Rezoning Transportation Analysis

Petition Number: 2021-094

Date	Description
08-25-2021	First Review (LH)

**RZ1.0**

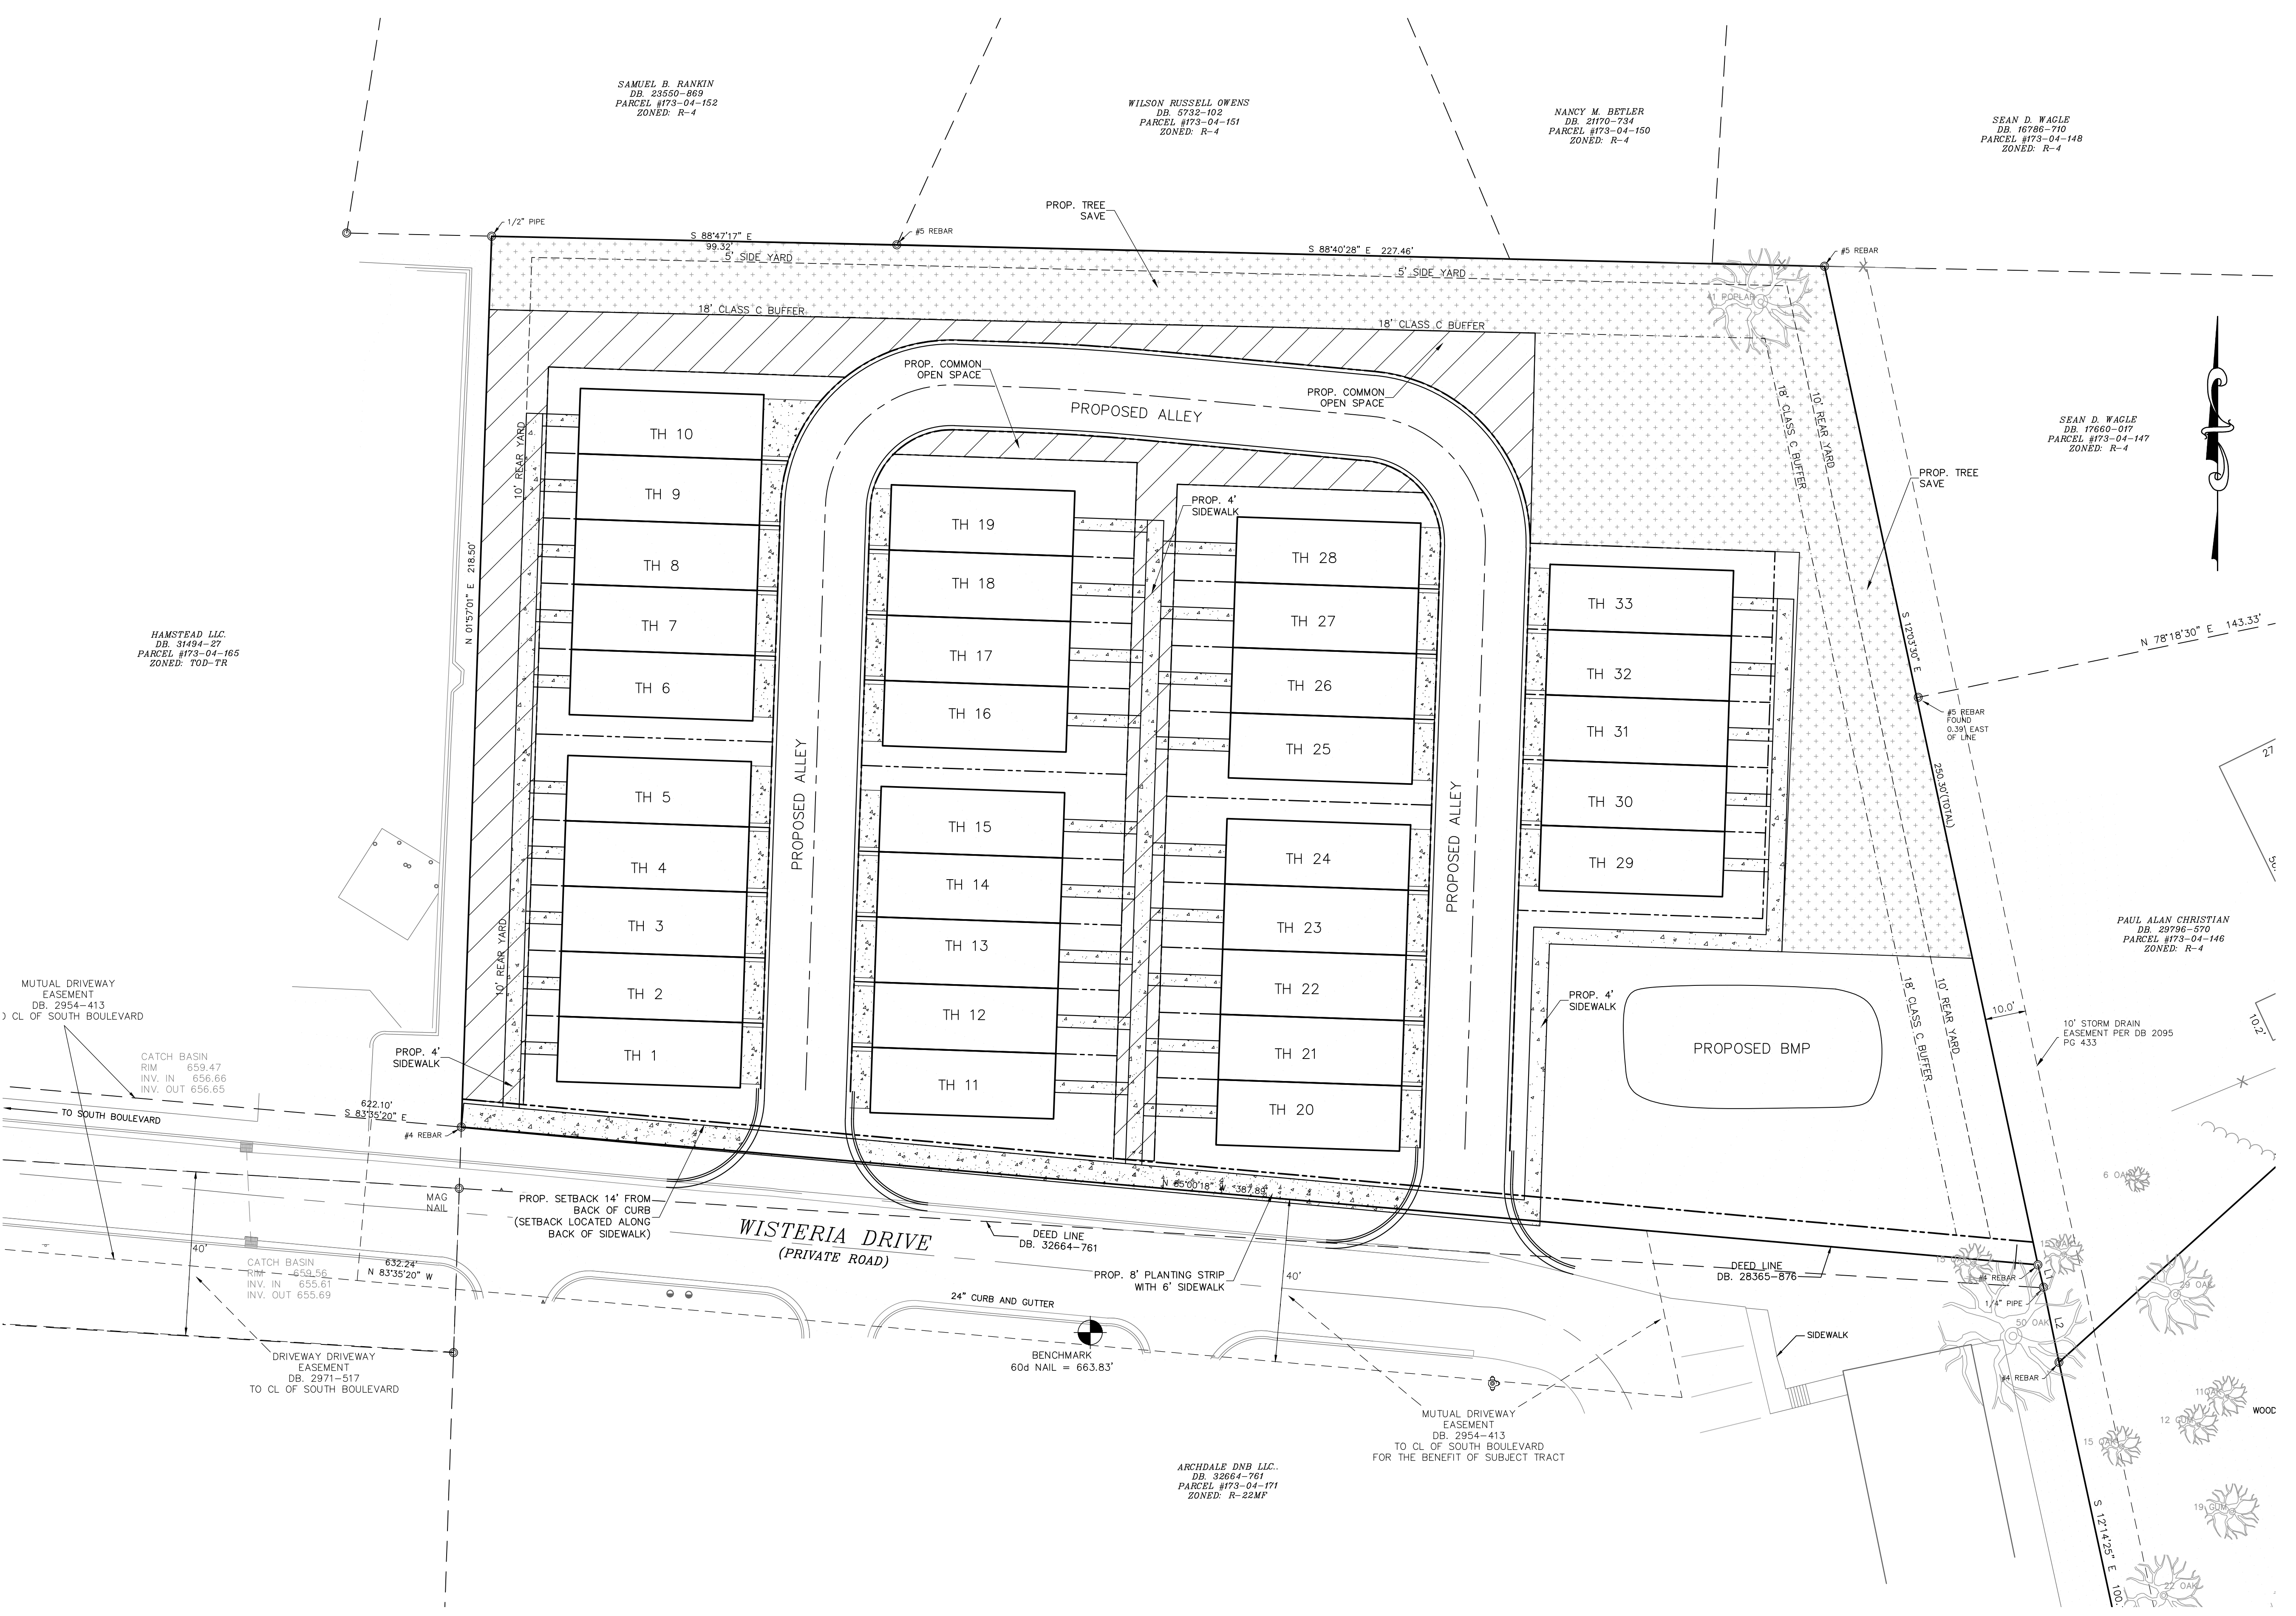
1. **Curblines:** The proposed zoning district has a setback measured from back of the existing or proposed future curblines.

Wisteria Drive: The future location of curb and gutter is in its existing location.

3. Revised Site Plan Conditional Note E. Streetscape and Landscaping (2) for the sidewalk utility easement to include 2' behind back of sidewalk, where feasible.
4. A site plan note specifying that all transportation improvements will be approved and constructed before the site's first building certificate of occupancy is issued is needed. The petitioner may phase transportation improvements if said improvements and phasing are explicitly described in site plan notes.
